Ribble Valley Borough Council

**App no: 25.0688**

**Address: Former Genus Site (Units 1-21 Mitton Road Business Park) Mitton Road Whalley BB7 9JY**

**Proposal: Proposed reinstatement of previously approved phase 1 entrance, including a timber fence between phase 1 and phases 2/3**

Client A I Land Ltd		
Project Proposed Alterations to Phase I Entrance at Mitton Road Business Park Whalley		
Drawing Title Existing and Proposed Site Plans		
Scale 1:500 @ A2	Date Aug 2025	Drawn LFR
READ DESIGN LTD		
102 - 09 c

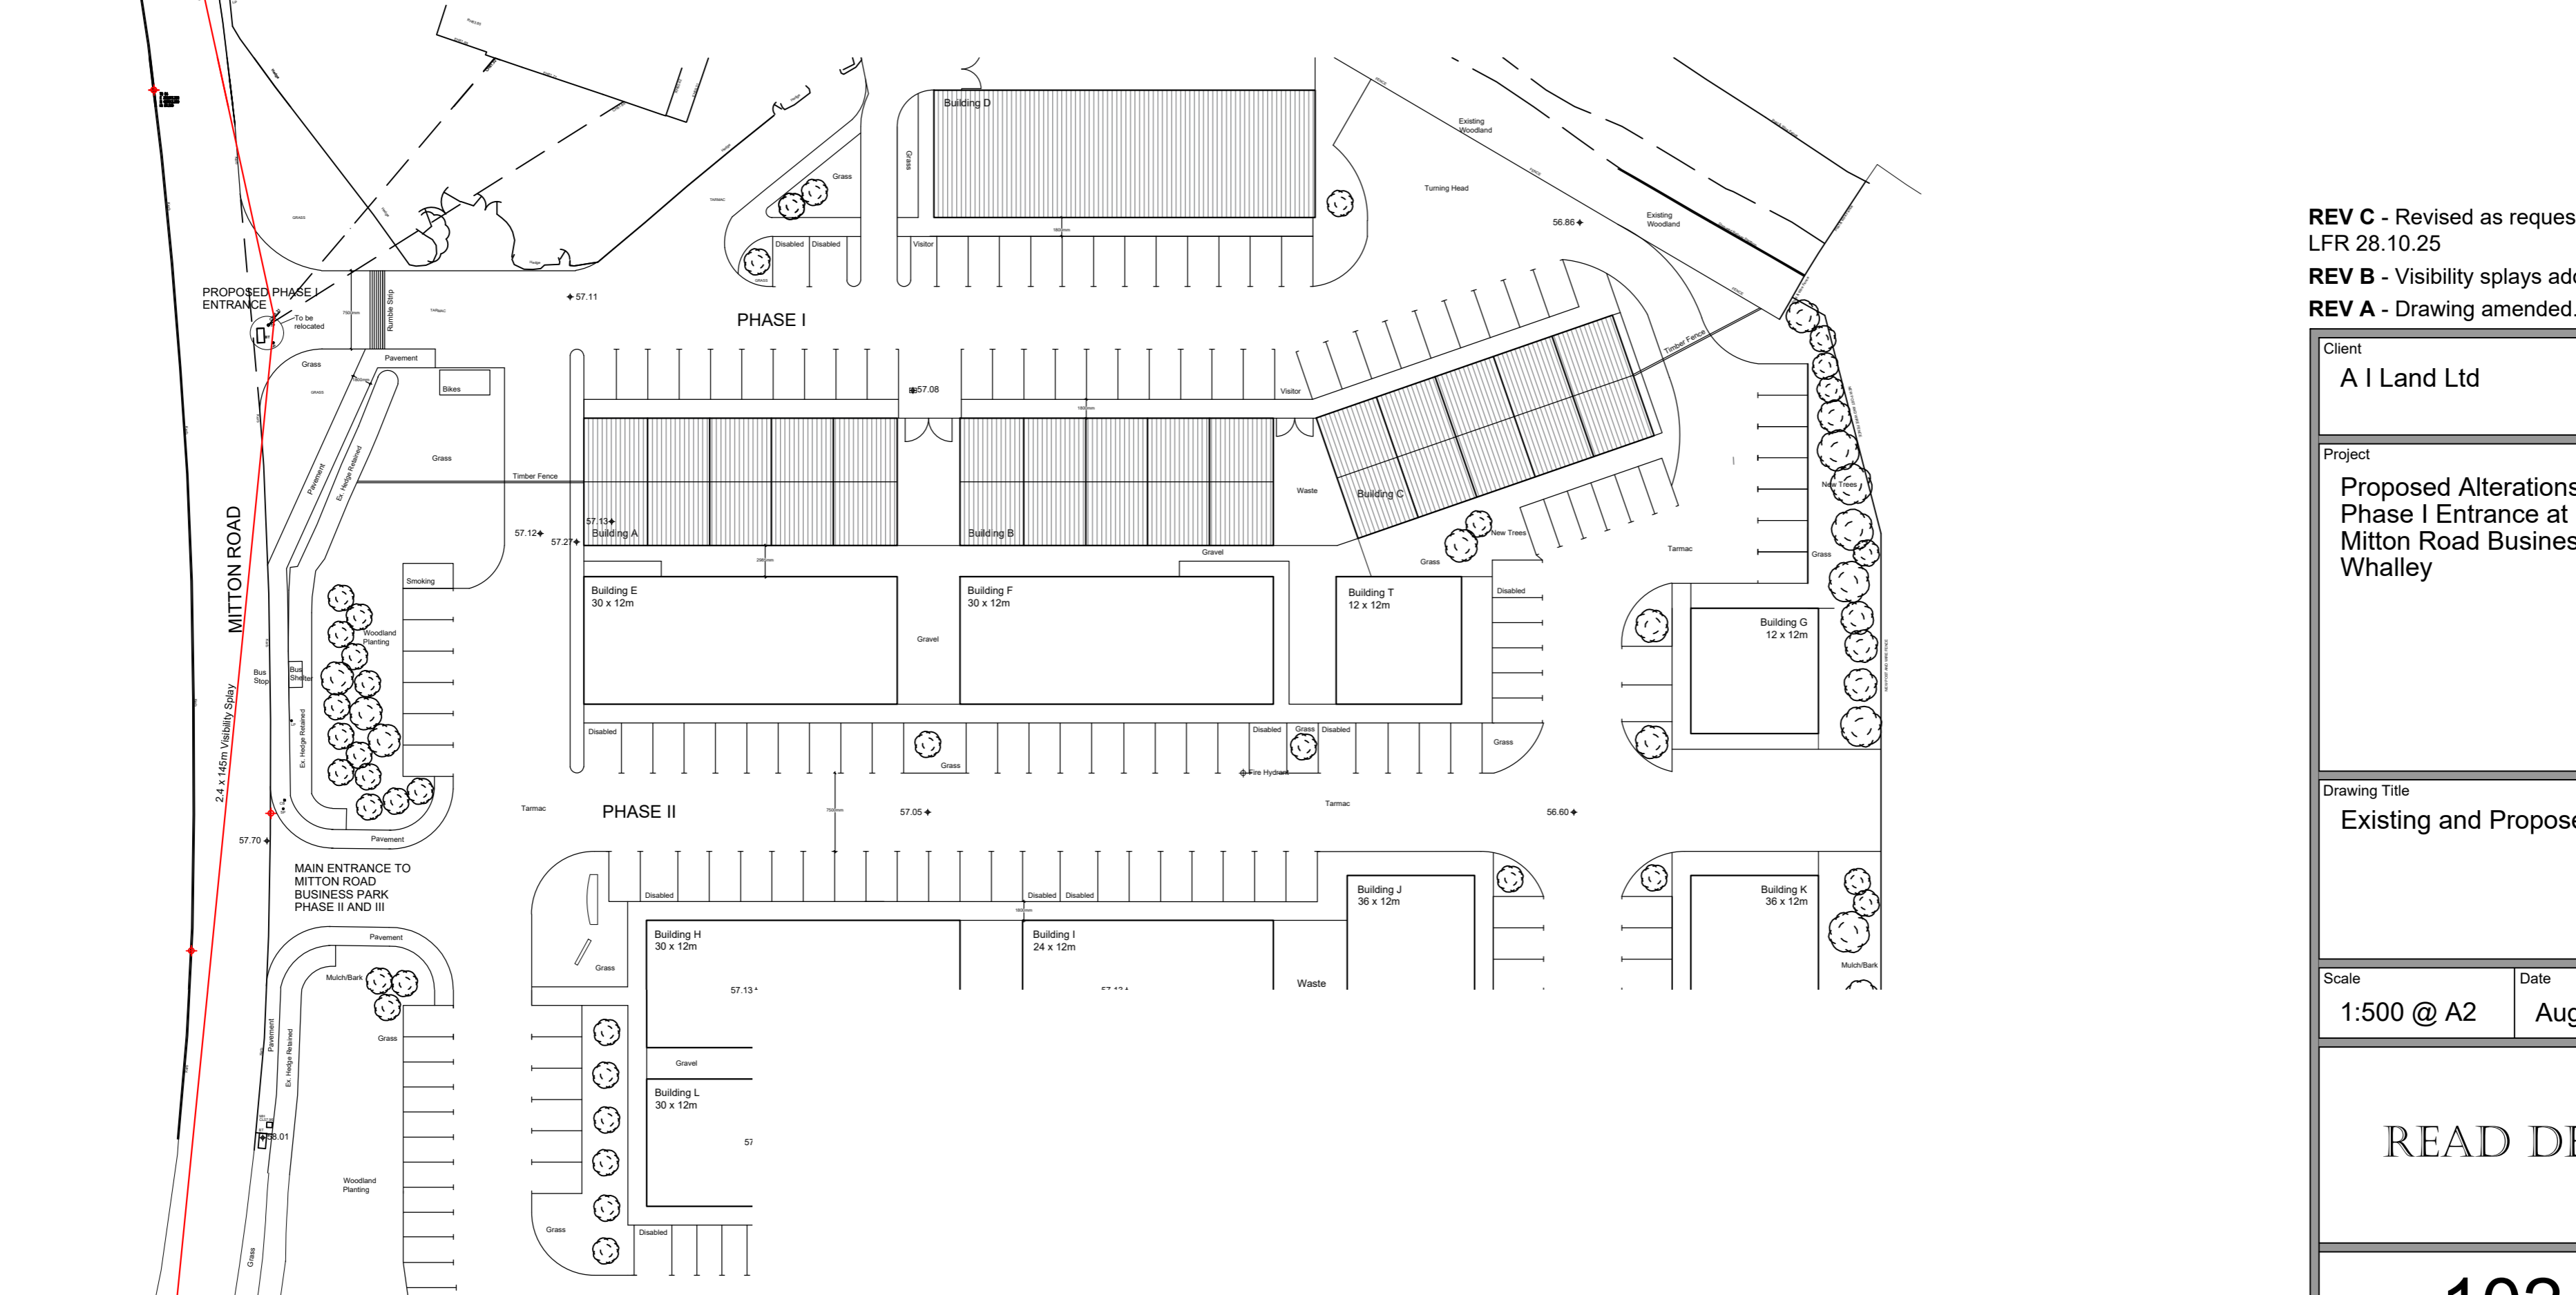
The visibility at the site access is considered acceptable. Splays of 2.4m by 90m to both sides are required and can be achieved over the highway or applicants land.

The access has been increased in width from 5.5m to 7.5m as previously requested. The radius to both sides needs to increase from 6m to 12m to accommodate the longest articulated vehicles.

The proposed internal separation of Phases 1 and 2 will prevent access to the communal parking areas for the Phase 1 units. It is recommended that pedestrian

access is maintained between Phases 1 and 2 for overspill car parking unless additional information is submitted to demonstrate that the proposal will not impact upon parking.

Upon visiting site, it was evident that cars were parking in undesignated areas and that this may be limiting access through the site for articulated vehicles.

The access is proposed at 7.5m carriageway to accommodate the large commercial vehicles, and subject to the radius being increased to 12m, this is acceptable in principle.

Lancashire County Council acting as the Highway Authority would request further information regarding the reason for the proposal and the parking provision and pedestrian access before the decision is made.
